Tween Bridge Solar Farm

9.9 Statement of Common Ground with Natural England

Document Reference: 9.9

Revision 4

Project	Tween Bridge
Drawing Title	Non Breeding Bird Mitigation Plan
Scale	As Shown (Approximate)
Drawing No.	16413/P14g
Date	July 2026
Checked	TLR/RR

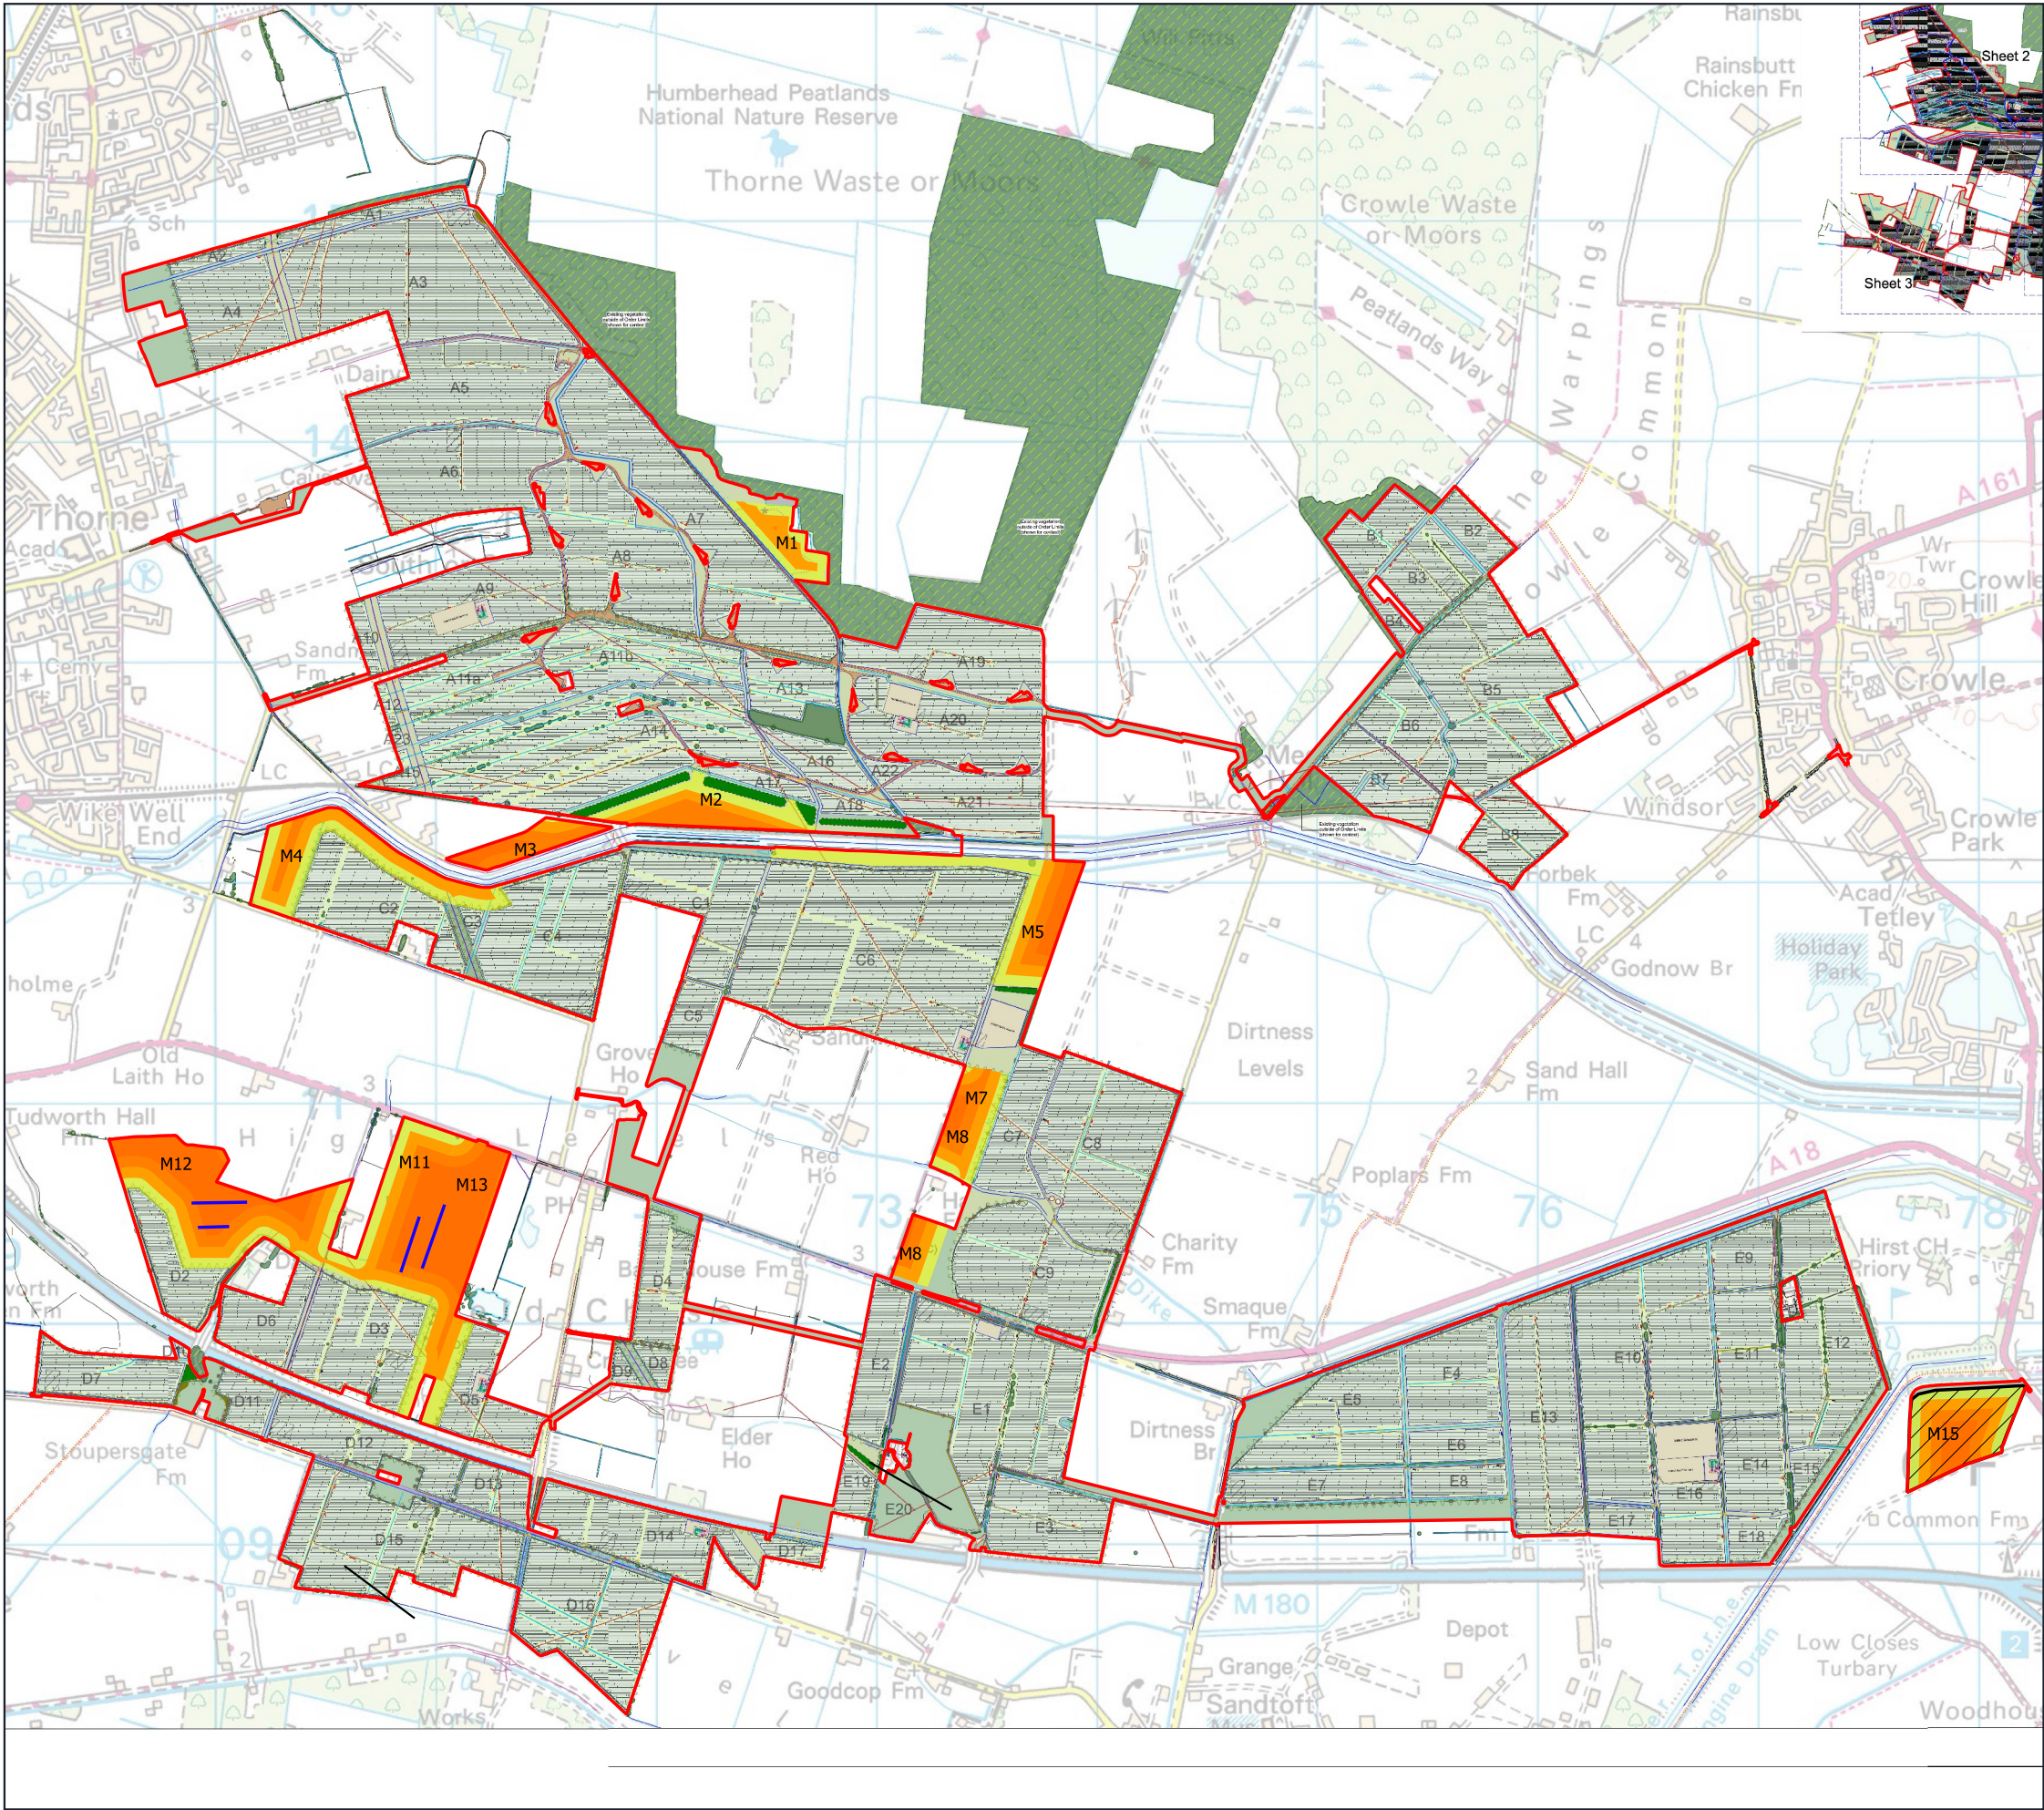
[REP5-006] and provided as part of Figure 1 within this document. Several mitigation parcels larger than 10ha with at least 150 m open vistas are provided, including M12 and M13. A total of 43.67ha of mitigation land with 150 m open vistas is located beyond 600 m of wind turbines, in line with point NE3 (see below), and is available for lapwing. Bird Days calculations demonstrate that 24.99 ha is required for lapwing (Appendix 2 of the Report to Inform Habitat Regulations Assessment [REP5-006]), confirming that more mitigation land is provided than required. Additional mitigation land within 600 m of turbines, including parcels M1 and M2, is also available, and lapwing have been recorded using these areas, therefore ensuring that additional land is available for this species. When considering mitigation land beyond 600 m of turbines, 108.84ha remains available for	
--	--	--	--	--

turbines, including all of areas M4, M7, M8, M11, M12, M13 and M15, and the majority of M3 and M5, totalling 152.51ha out of the total 187.32ha proposed. This ensures that there is sufficient mitigation land provided beyond 600m of turbines, as demonstrated by the Bird Days calculations, which Natural England have confirmed are accurate (see email correspondence dated 10.07.2025 – see Appendix 1), and which have been completed in addition to ecological knowledge of the carrying capacity of different habitat types, which is also in line with Natural England’s correspondence when they state that ecological knowledge should supplement the bird days calculations to demonstrate that there is suitable habitat provision for the numbers of birds displaced by the development.. The Applicant confirms that Figure:16413_P16a_600m Buffers_TLR_RR is attached at the end of this document.	
--	--	--	---	--
